FIRE RISK MANAGEMENT, INC

Memo Report

Subject: Independent Fire Protection Review for Cumberland County Civic Center Renovations

A review has been completed of the updated sets of fire protection construction documents (CD), which have been developed to support renovation efforts at the Cumberland County Civic Center in Portland, ME. The documents reviewed included both the fire protection demolition and design drawings (updated 4/12/13), along with the design specifications (updated 4/2/13) for the various fire protection and life safety related systems and the Building Code Report (dated 4/16/13).

- ④ CONNECT TO FIRE ALARM SYSTEM FOR AUTOMATIC OPEN ON ACTIVATION OF SMOKE CONTROL SYSTEM (ZONE 3).

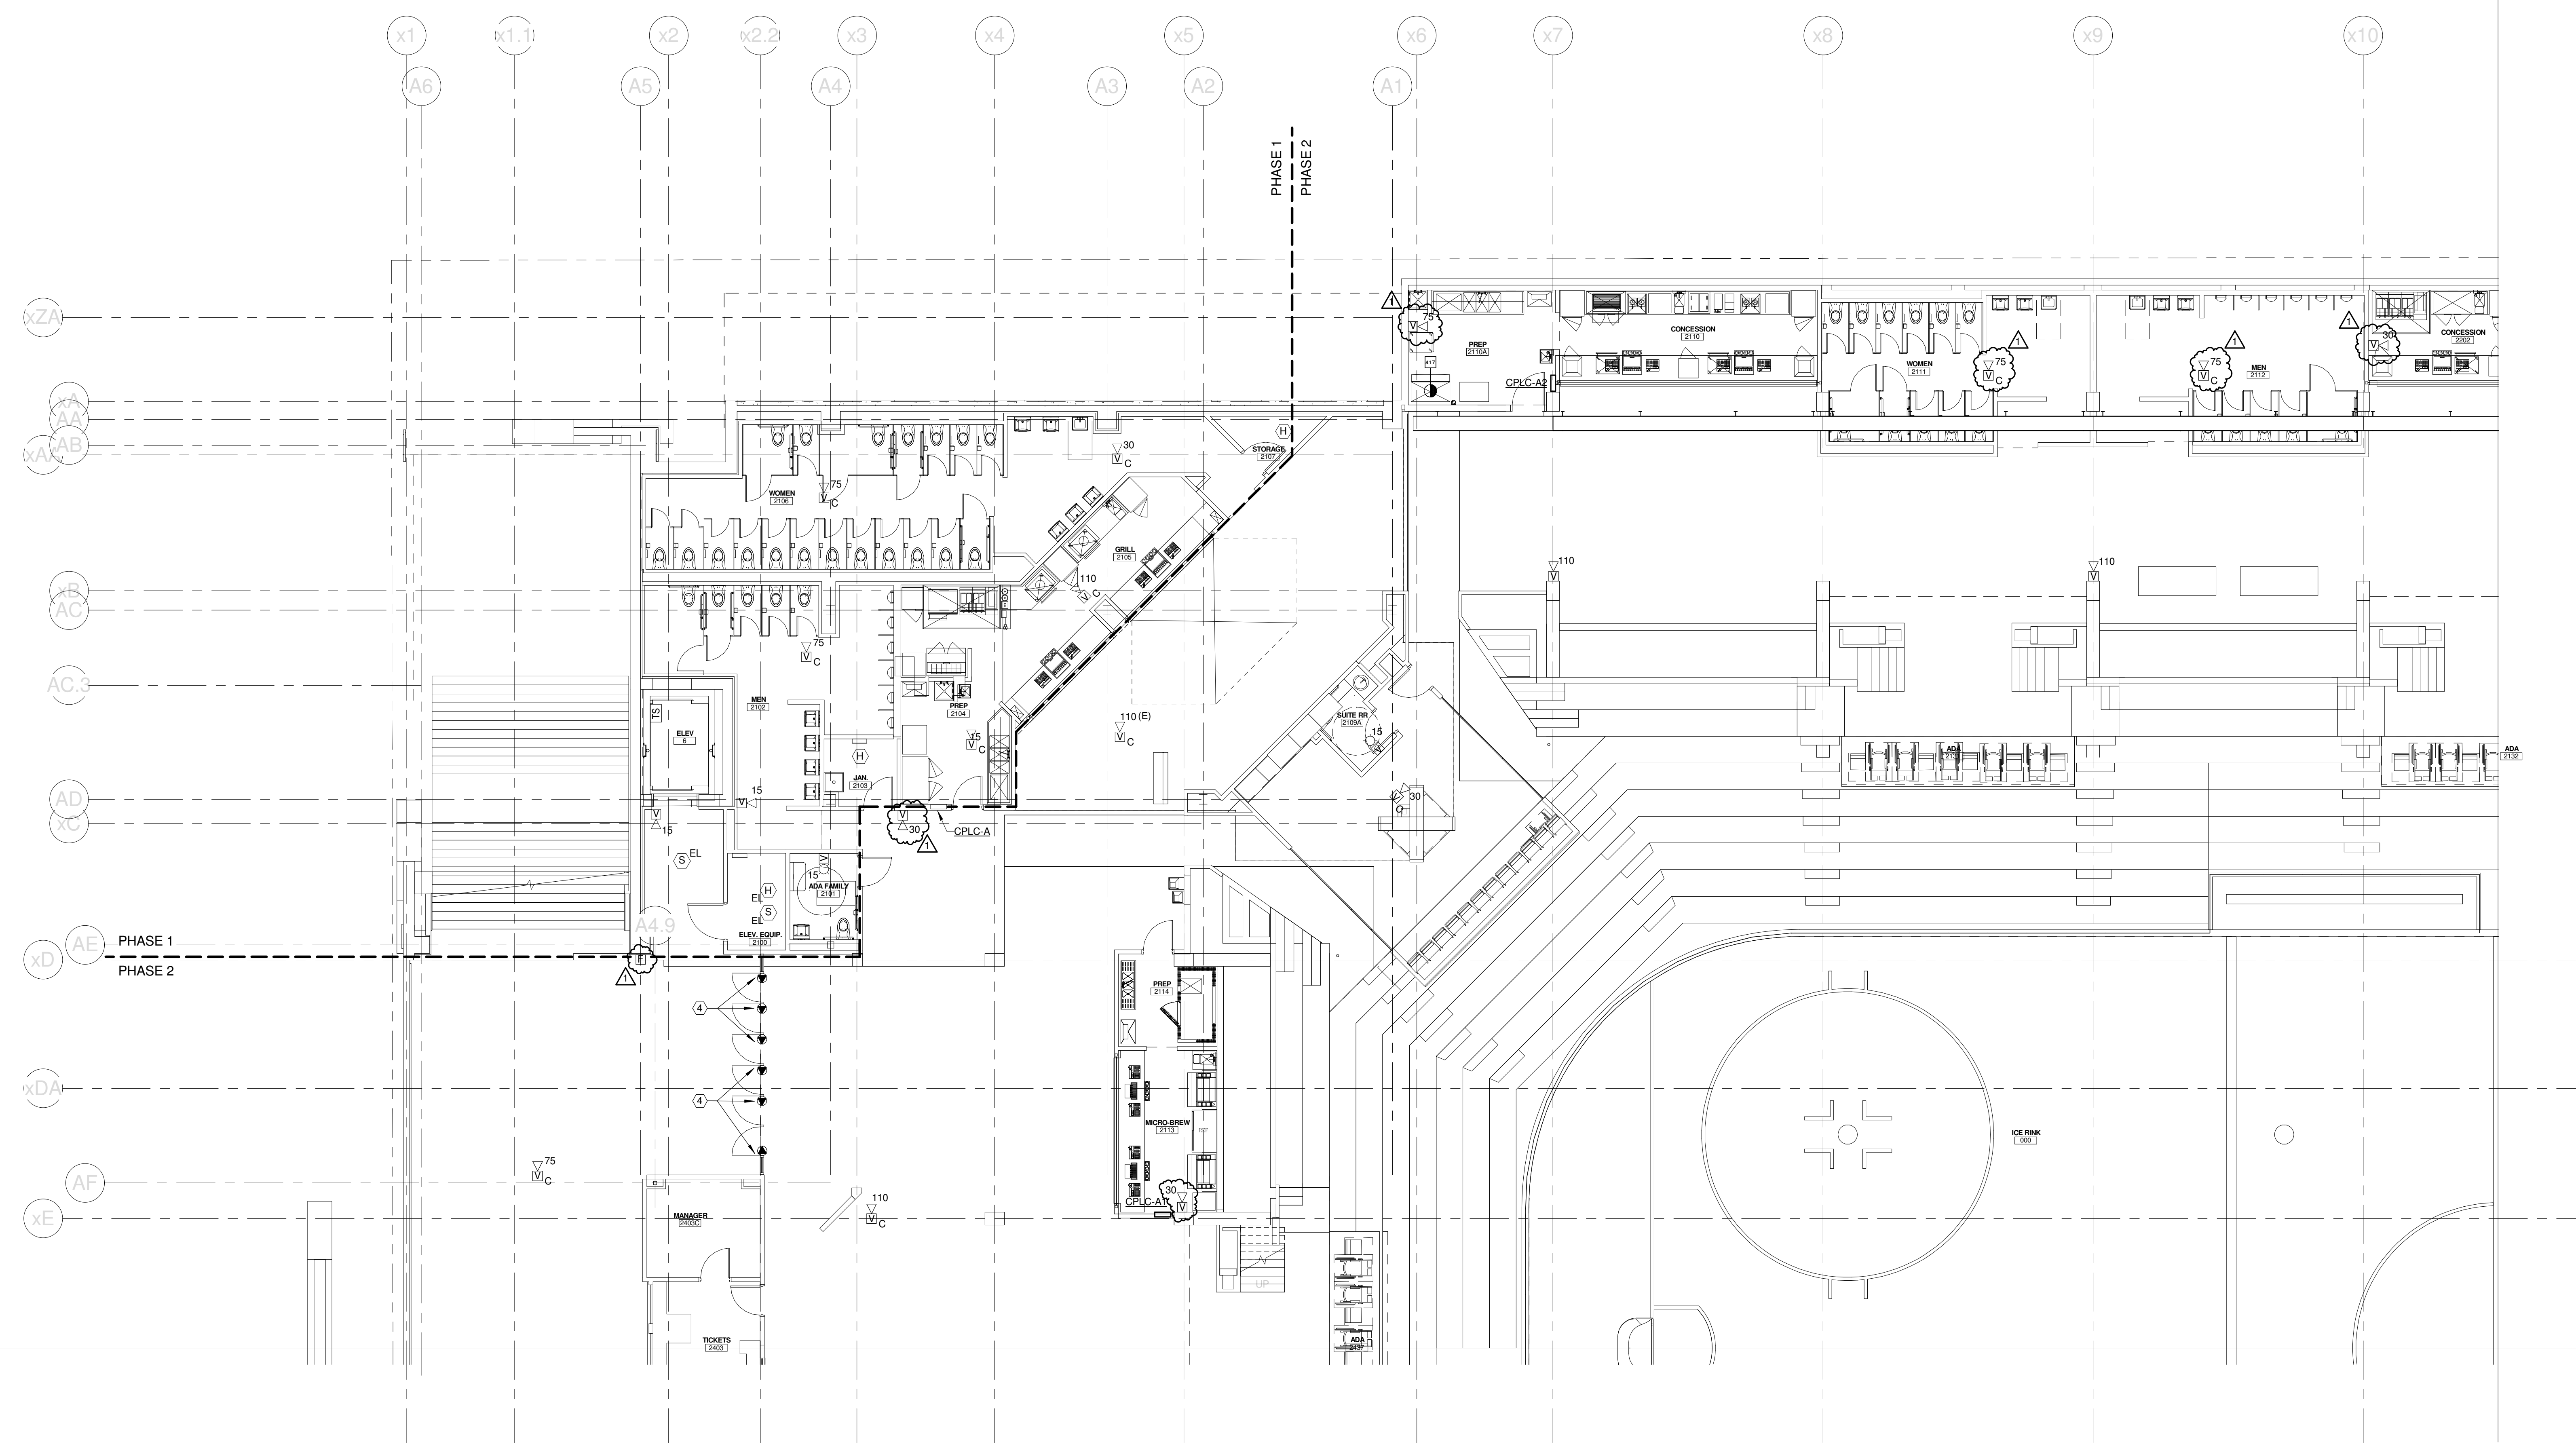
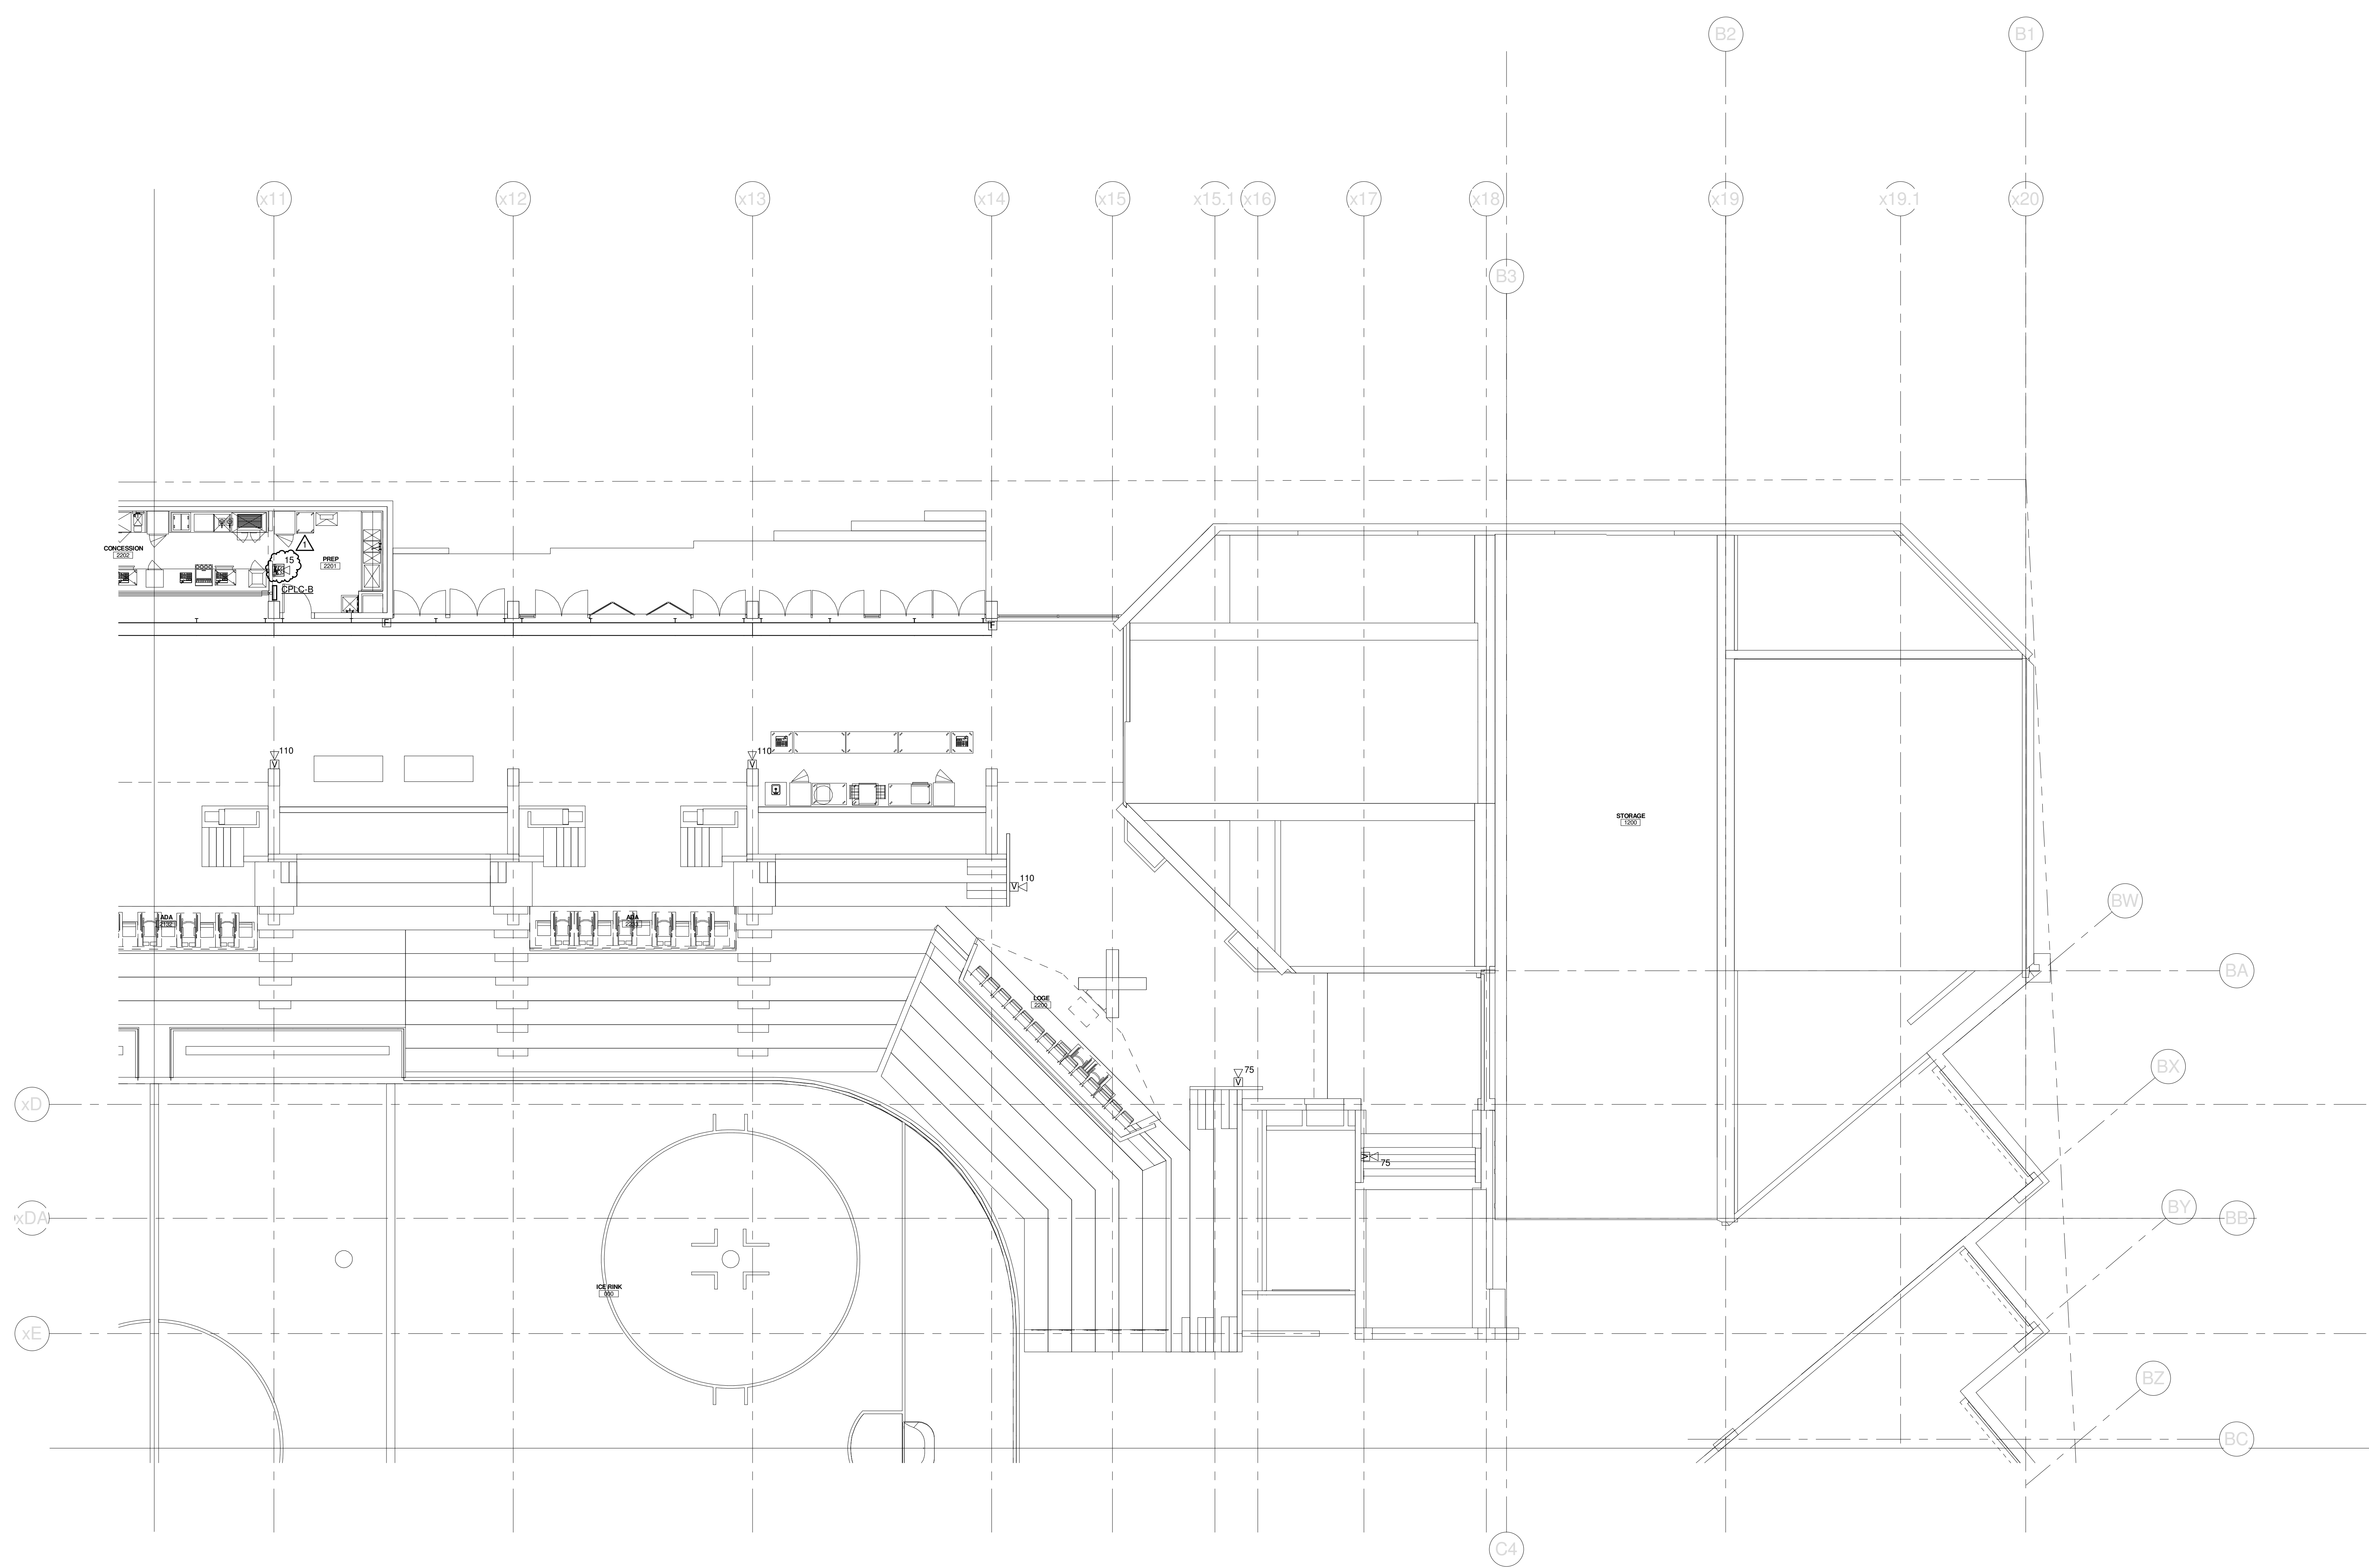
A detailed review of the Fire Alarm system drawings indicates that a number of questions and concerns still exist. Specifically, this includes the many heat detectors that are installed throughout the various spaces within the facility. These devices are unnecessary, given that this facility is fully protected by automatic sprinkler systems, and will represent not only a notable capital cost, but also a significant life cycle cost to the City of Portland. The inclusion of these devices, along with a number of smoke detectors that are not required (such as in corridors of office areas in NW mezzanine), should be verified with the client to ensure they understand and agree with this approach. These devices will provide very little benefit to the overall life safety and fire protection of this facility.

It is recommended that the plans for locating notification devices be reviewed. Specifically, this involves areas that do not require the installation of visual devices, but must still comply with the audibility requirements. Given the locations of the planned notification devices as depicted on the drawings, consideration should be given to the addition of speakers within some of the other non-public spaces that are either relatively large or located such that the sound from the closest speakers may be insufficient to achieve code compliance. It is unknown if any prior sound measurements have been taken to establish “ambient” noise levels throughout the facility, but if not, a contingency plan should be developed to provide an allowance for additional speakers to be provided in areas that may demonstrate insufficient audibility levels during preliminary system testing. Currently, the system specifications do not require the installing contractor to perform such an evaluation prior to the installation of the system to verify device locations.

Based on this recent review, questions regarding the code compliance of the locations of notification devices exist for several areas, including; the Staging and Marshaling and First Aid areas at the west and east ends, respectively, of the Event Level, along with the general plan for notification within the Seating Bowl area. The specific floor to ceiling height within the Bowl area is not specifically depicted on the drawings, but it is believed that this exceeds the 30-foot maximum that is outlined in NFPA 72 for ceiling mounted devices. The only notification devices for the Bowl area are shown on the “Catwalk Level” plan. It is believed that the current plan for notification in the Bowl area would not be considered code compliant; especially as it pertains to the numbers and locations of devices that are installed to support this area.

Although notes exist on drawings identifying the beam type smoke detectors, these devices should also be identified within the legend for the drawings.
